## MEMORANDUM

**TO:** Jean Fraser, Planner  
**FROM:** David Senus, P.E.  
**DATE:** July 6, 2015  
**RE:** 1342 Congress Street Neighborhood Center, Final Level III Site Plan Application

REVISED OFF-SITE GRADING AND DRAINAGE PLAN

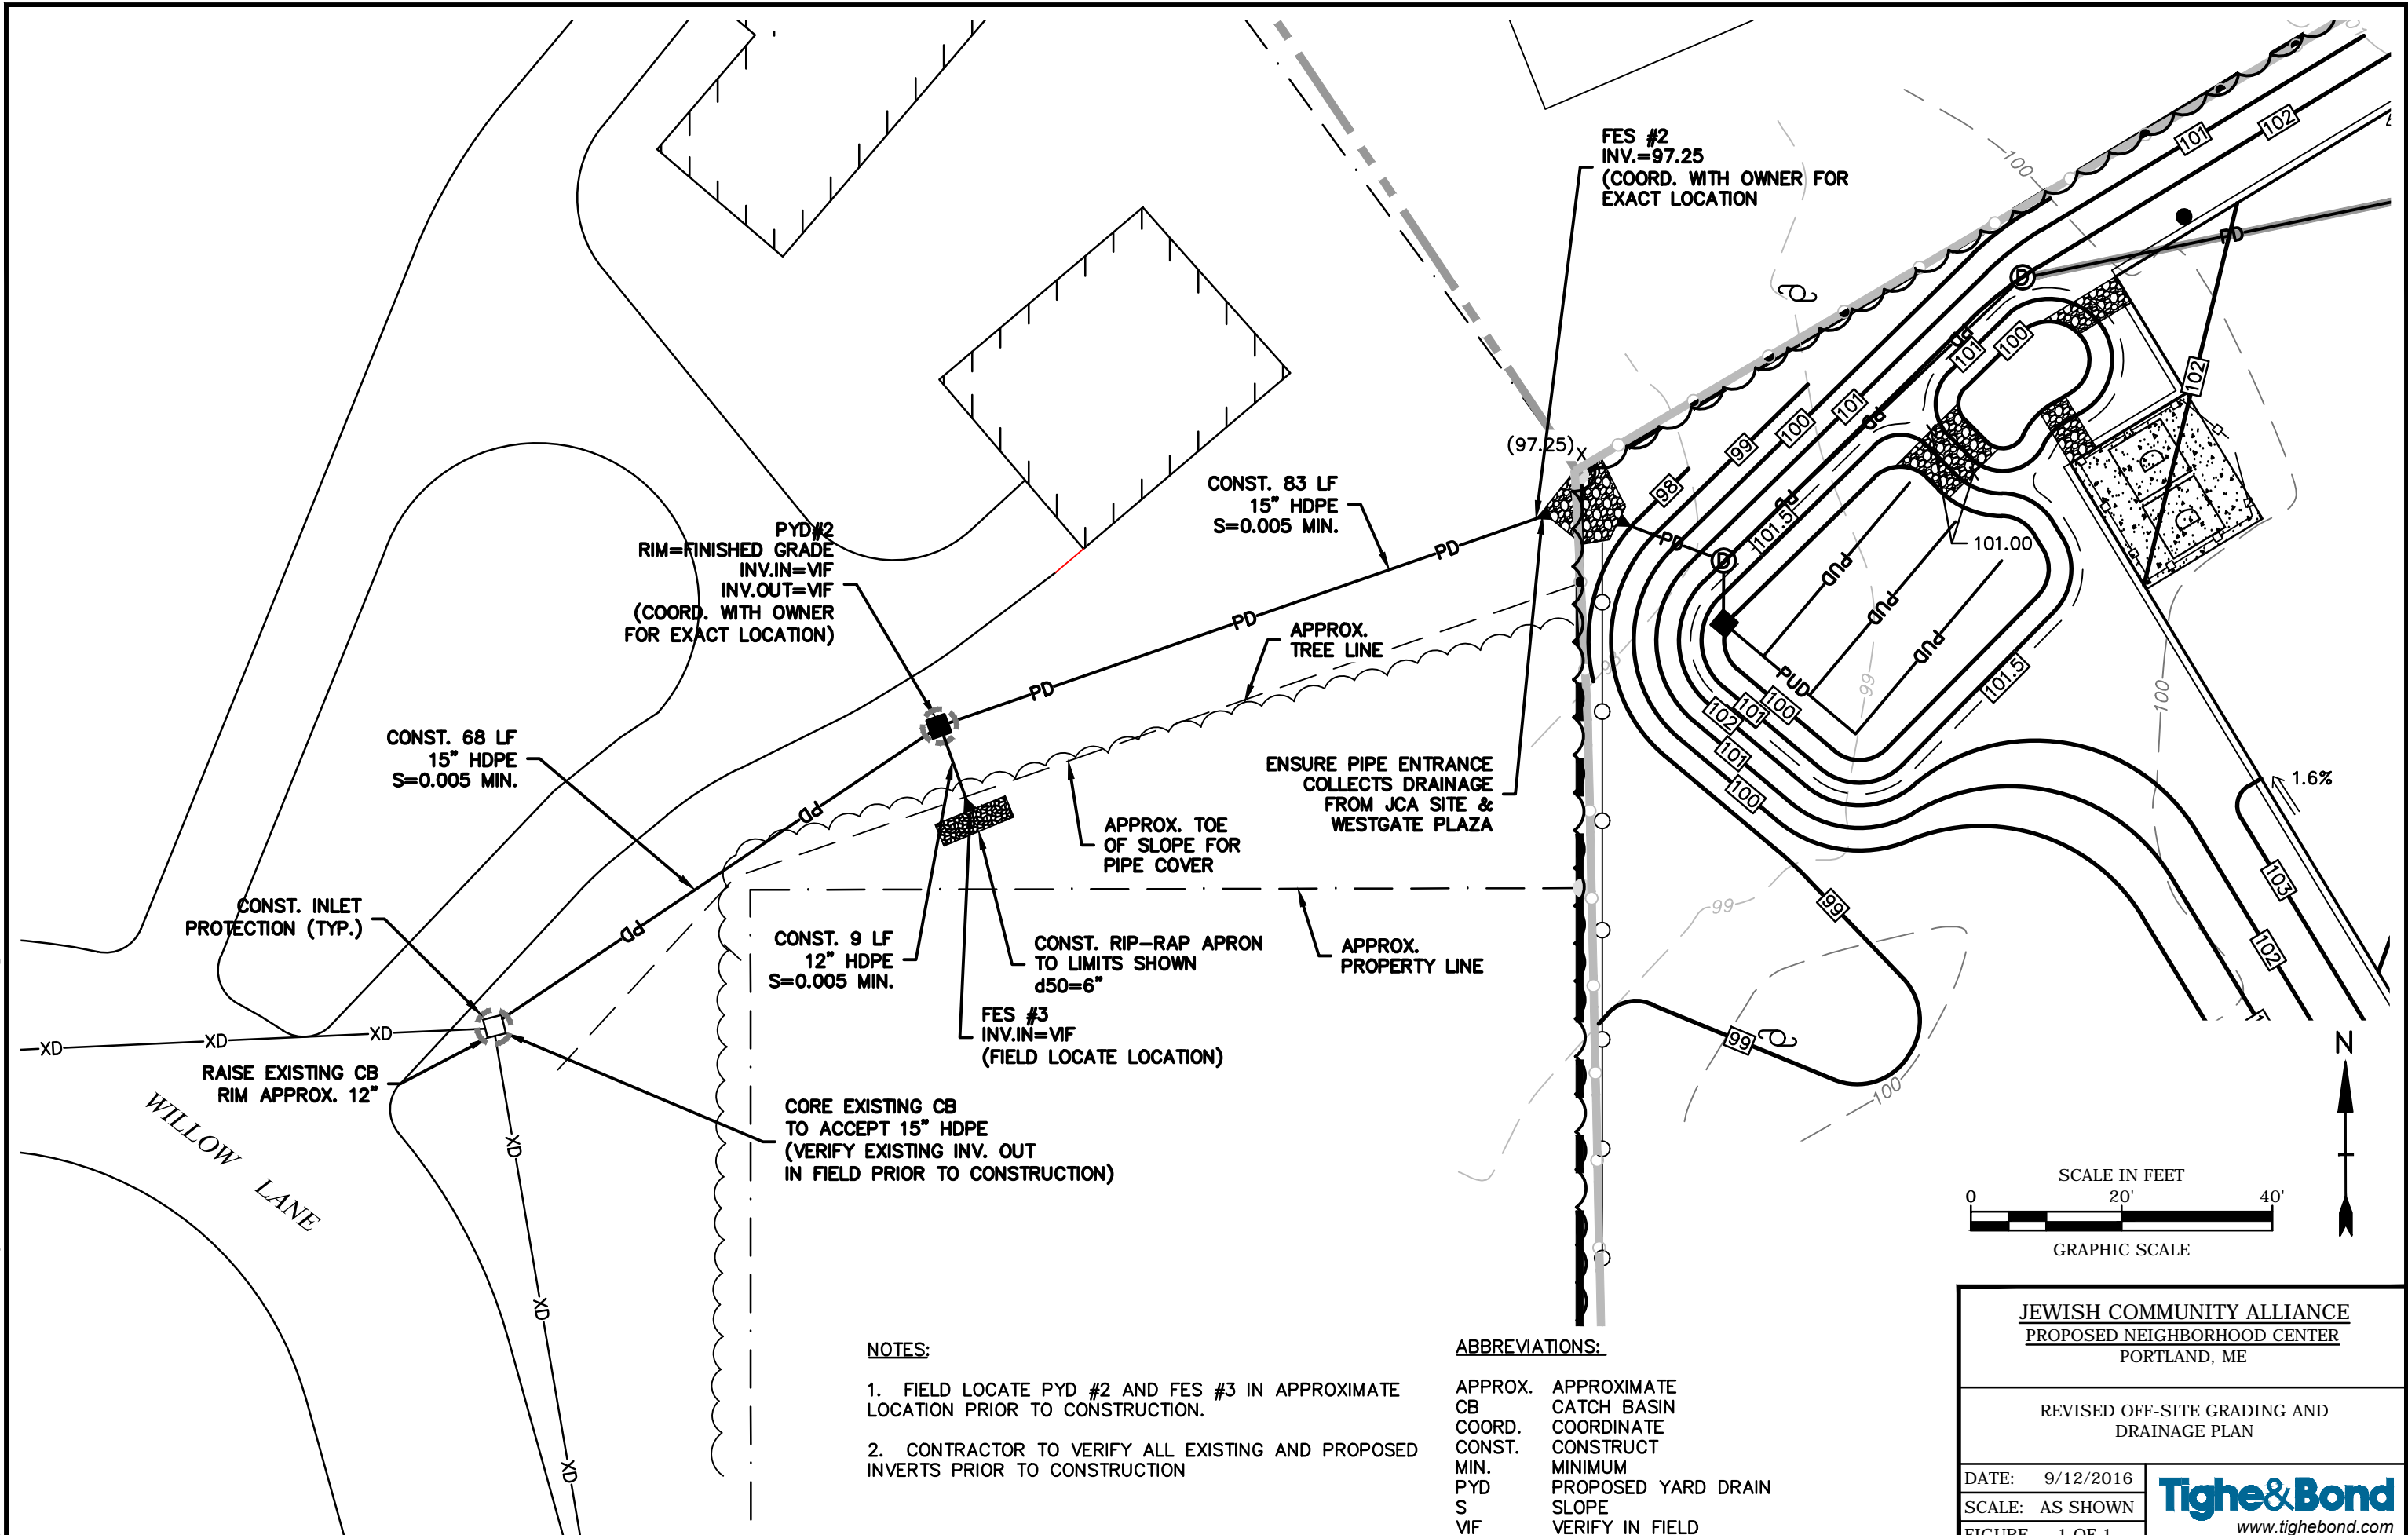
1. The Applicant has noted that they are currently working on completing a Temporary Construction Agreement with the abutting landowner at 60 Willow Lane for the installation of permanent stormwater conveyance features on the abutter's property, to be owned and maintained by the abutter, and will submit this agreement to the Planning Board prior to the meeting.
2. All previous review comments provided by Woodard & Curran have been adequately addressed.
